## PLANNING CONSULTATION RESPONSE

<b>Application No</b>	2025/1080
<b>Proposal</b>	Change of use of Working Men's Club (Use Class Sui Generis) to 9x supported living dwellinghouses for adults with staff facilities (Use Class C2) including associated alterations to the exterior of the building.
<b>Address</b>	2 Broad Street, Hoyland, Barnsley, S74 9DY
<b>Date of Consultation Reply</b>	13/03/26
<b>Consultee</b>	Highways Development Control

Drg No.  
2025-12/P01

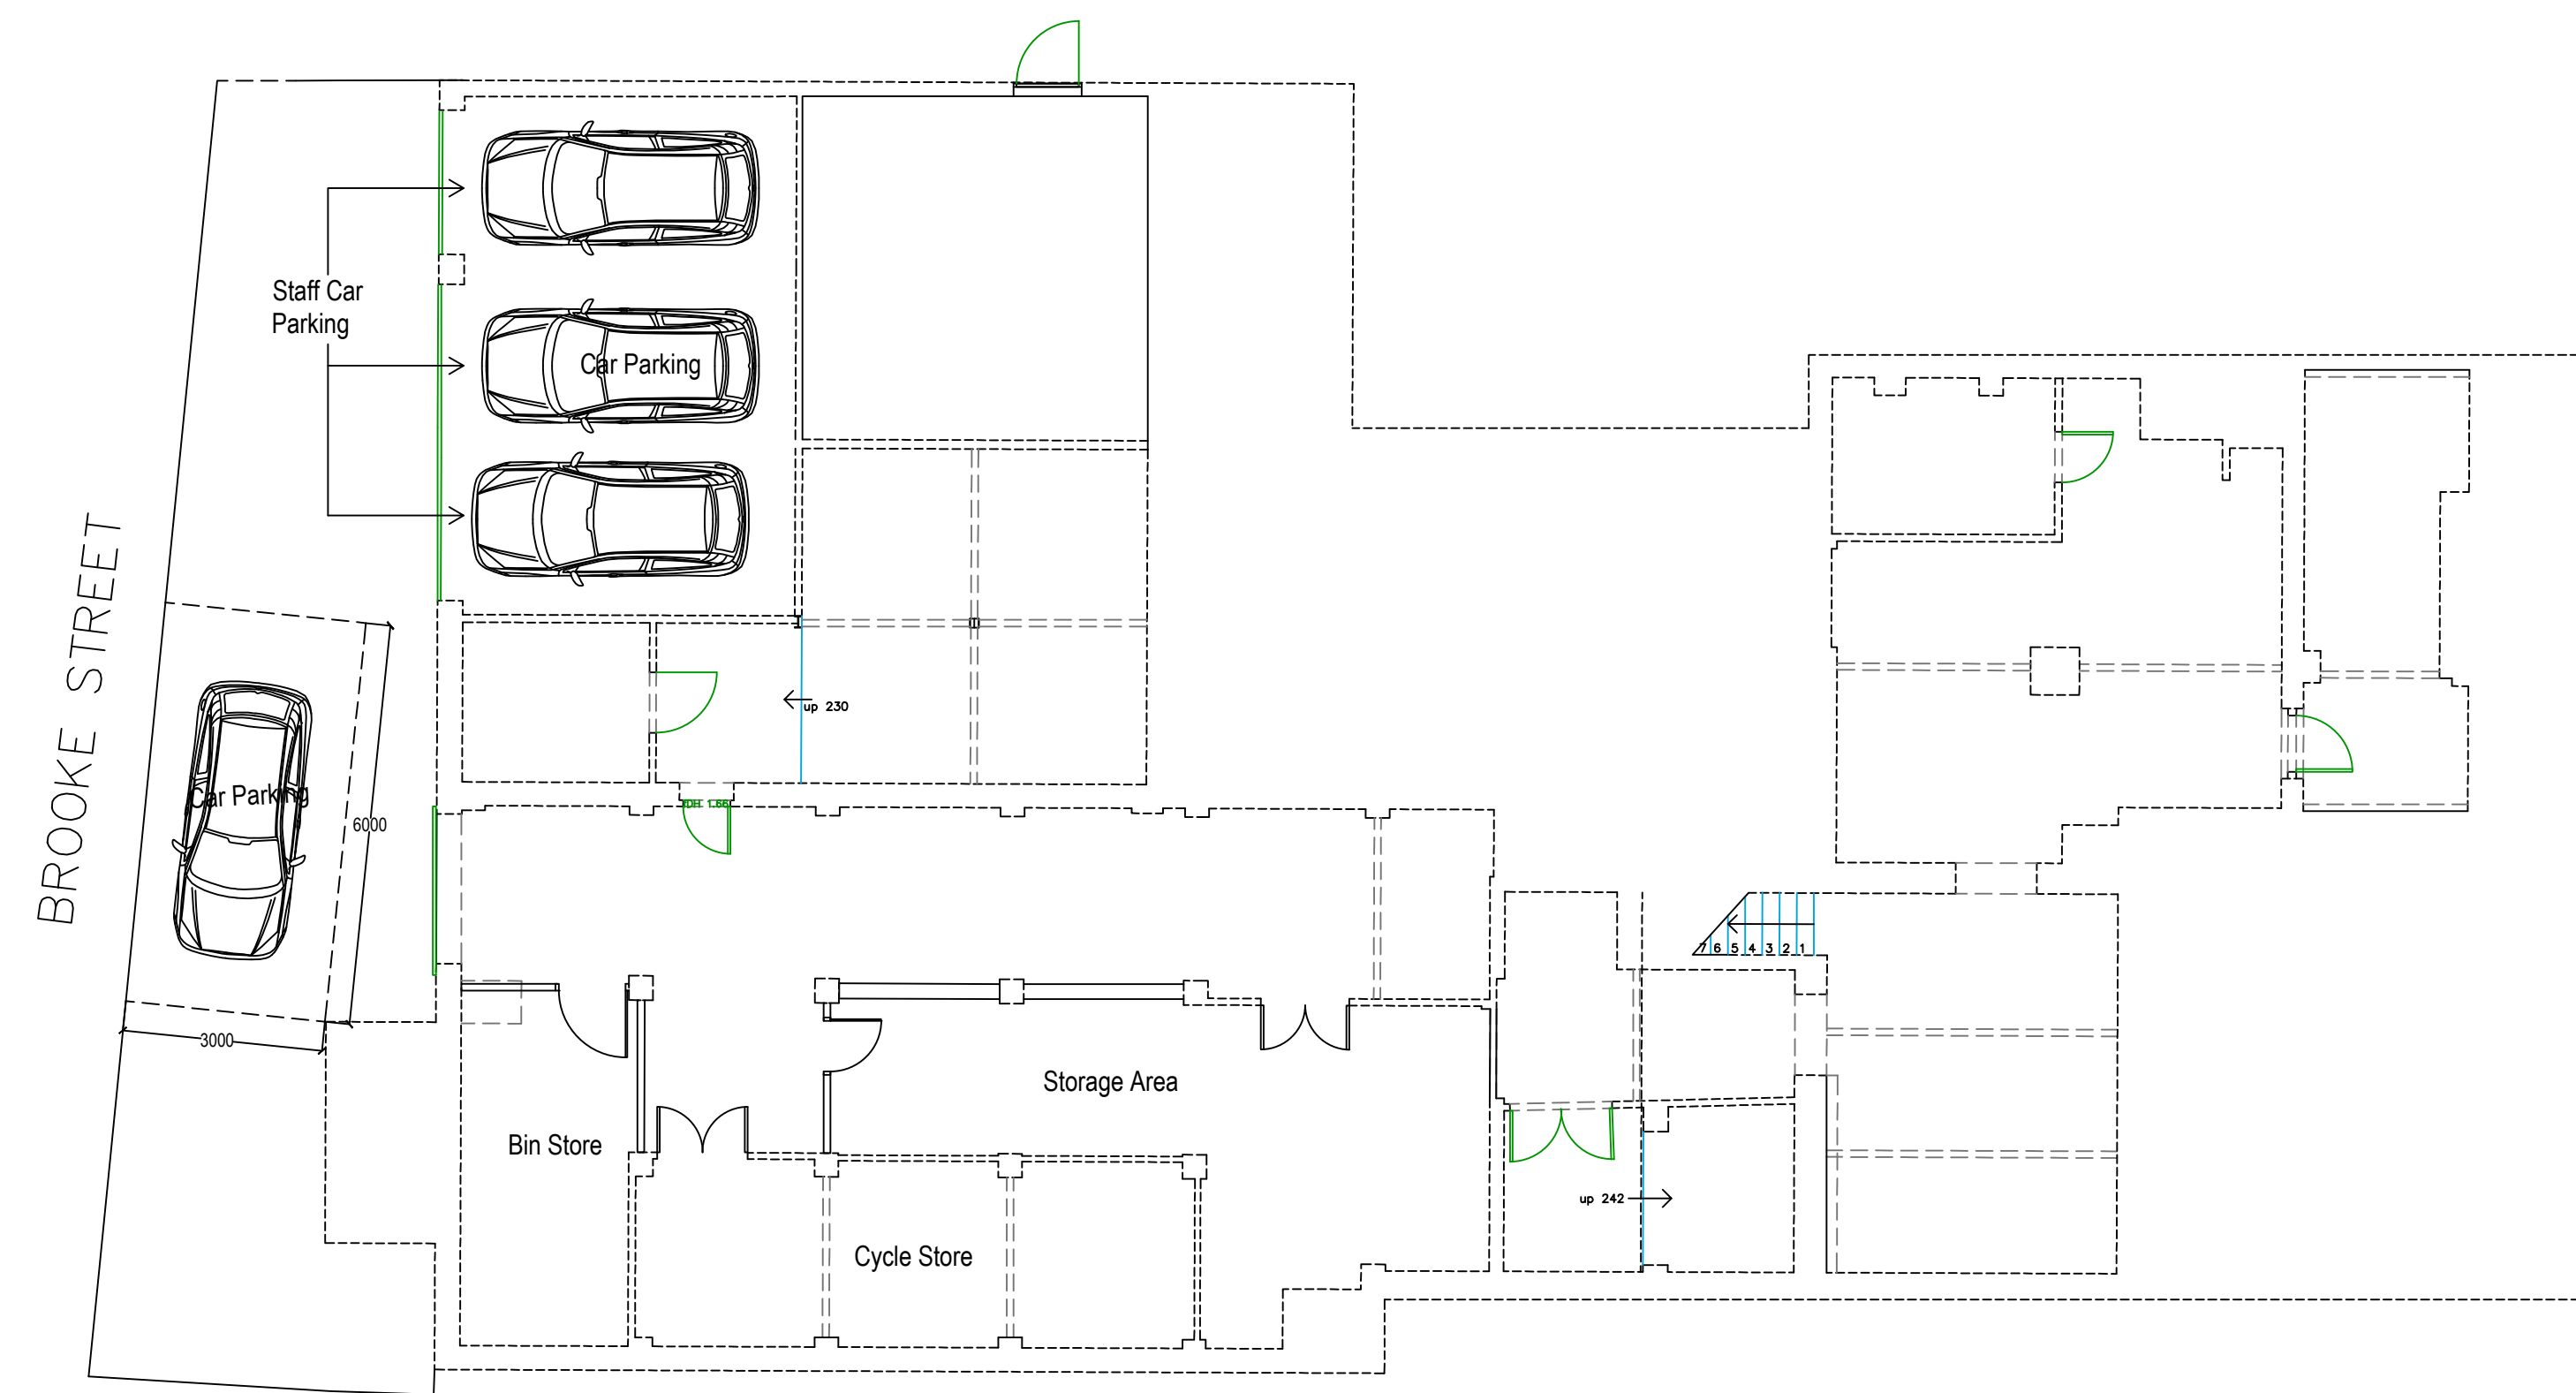
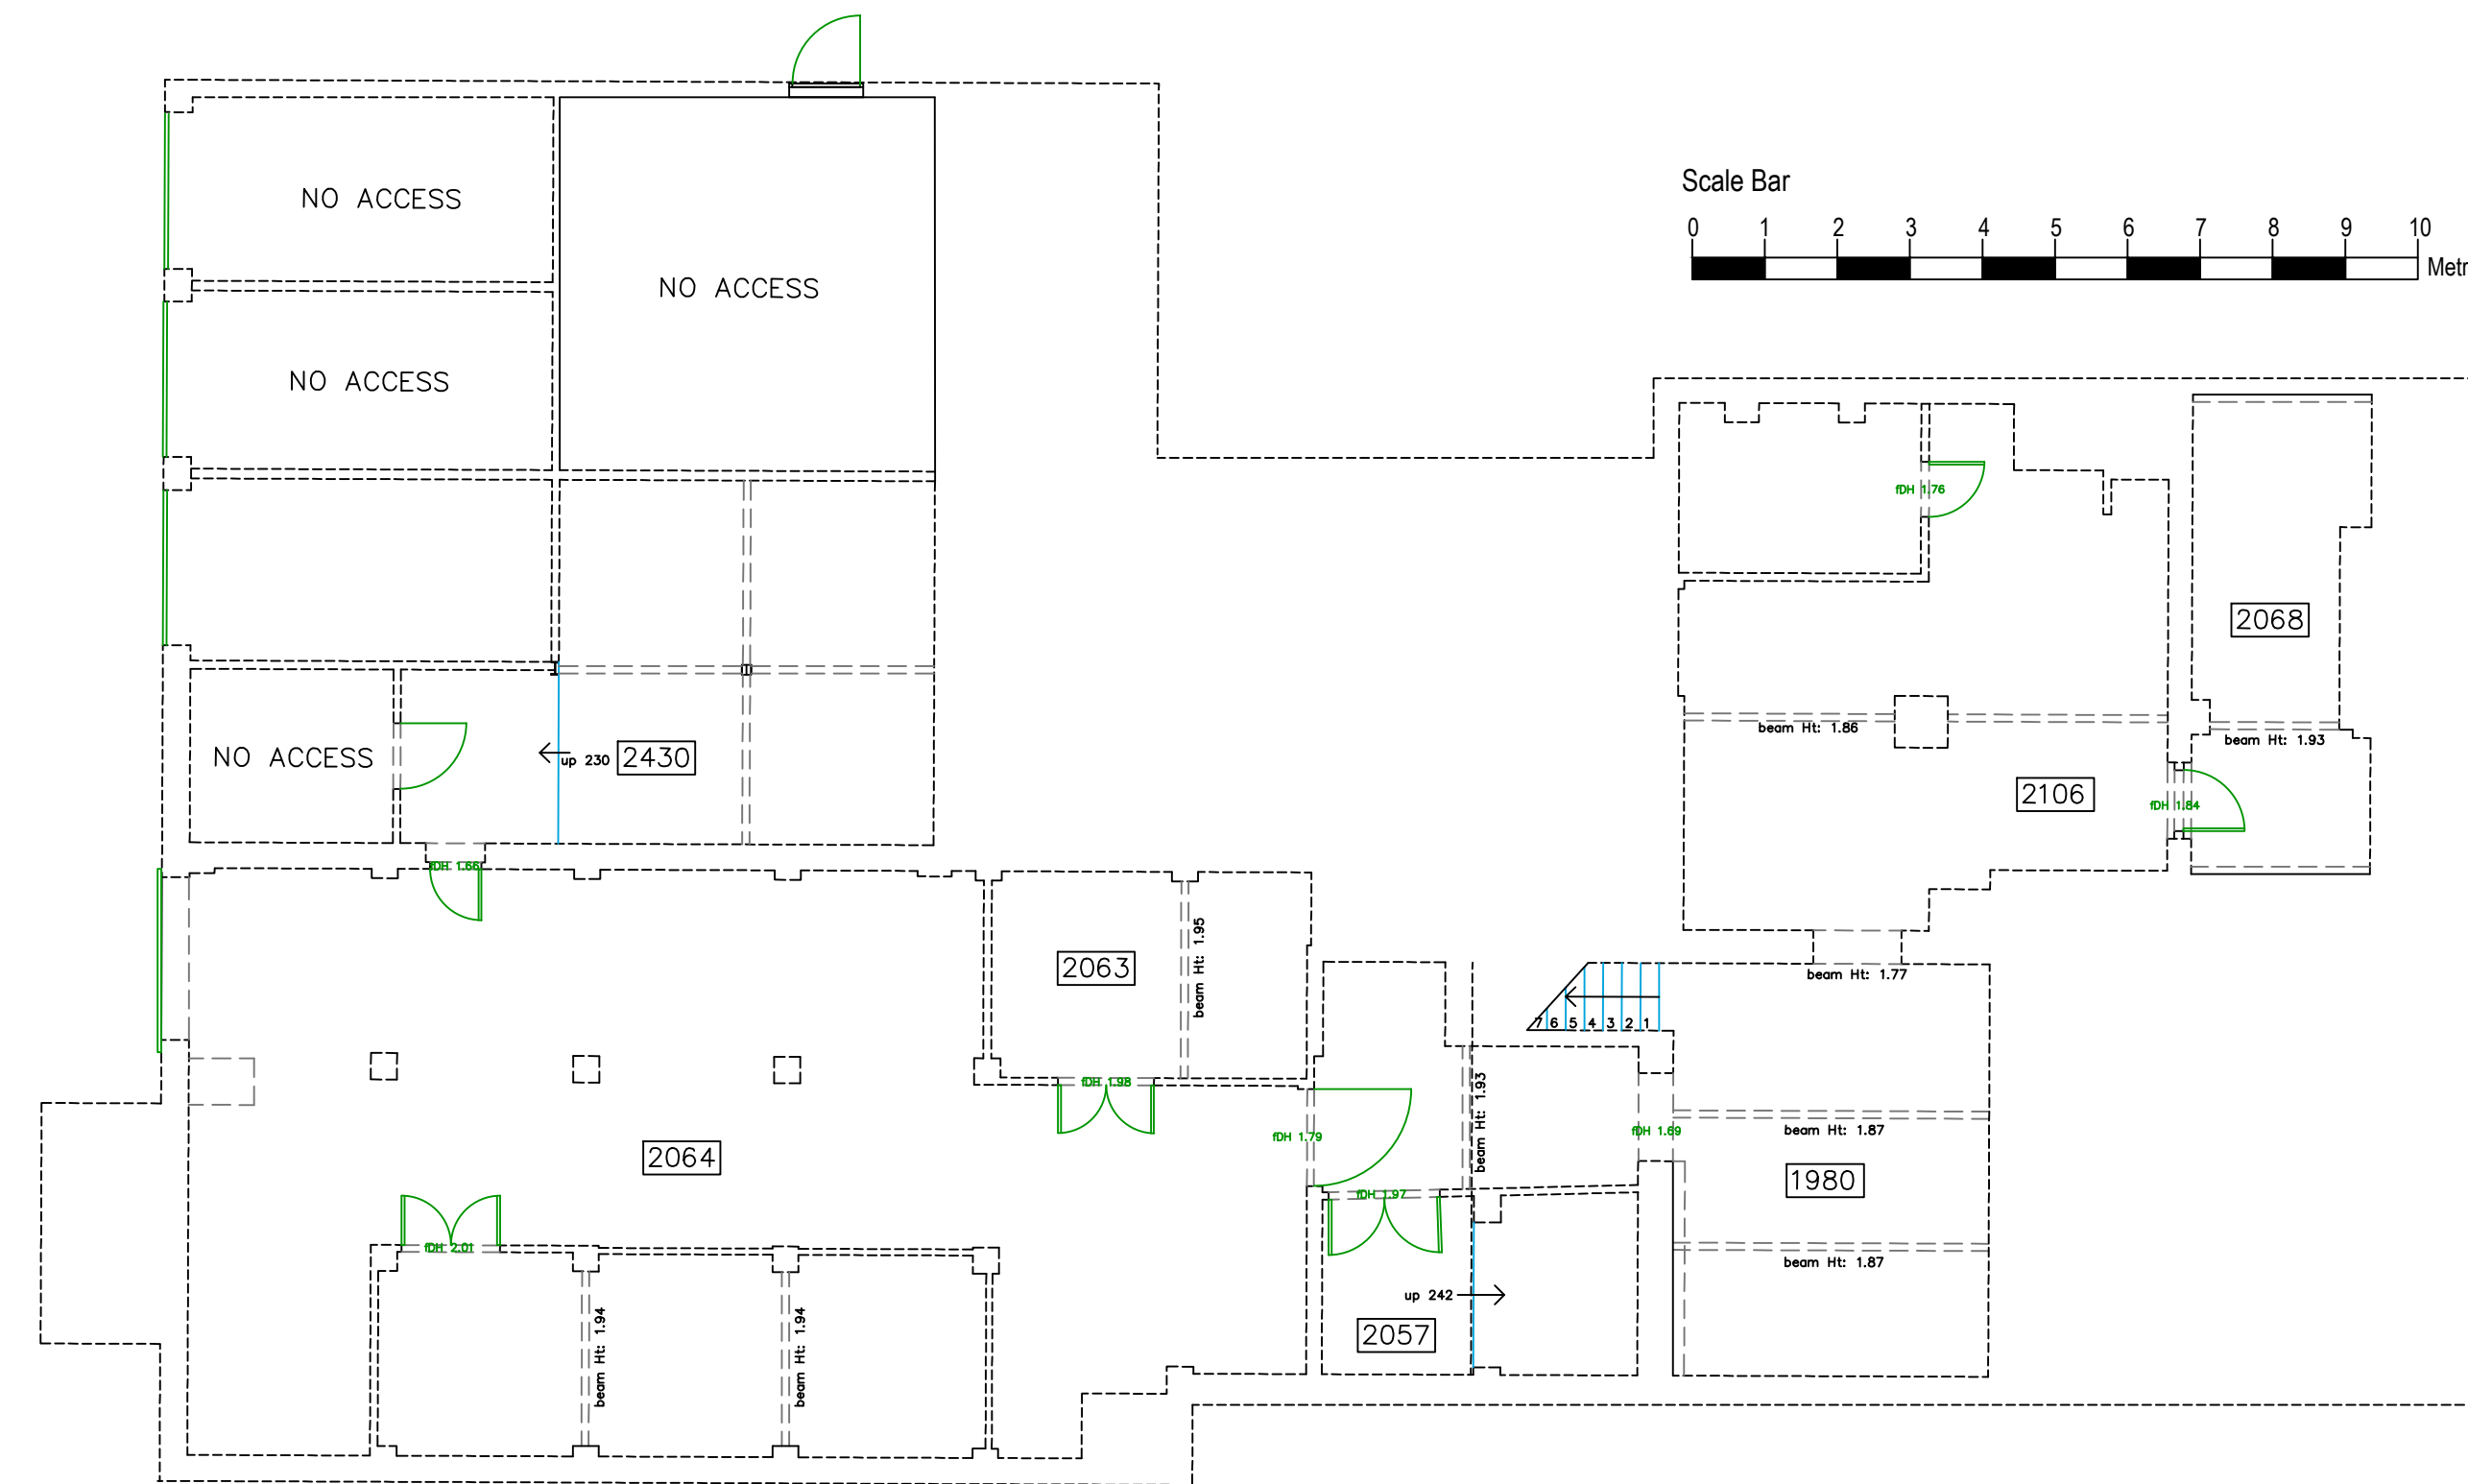
Many thanks for providing us with the amended site plan and parking layout.

The additional information gives a clearer picture as to the operation of the site and further to some research carried out as to the other facilities the applicant operated in and around the South Yorkshire area, it does look like the levels of parking proposed is aligned with the other provision that they offer.

Taking that into consideration, the proposal that has been recently submitted is adequate, and the removal of the solid garage walls to provide more of a carport arrangement would be acceptable.

As such, predicated on the changes proposed on site plan 2025-12/P01 rev B, I would have no further objections.
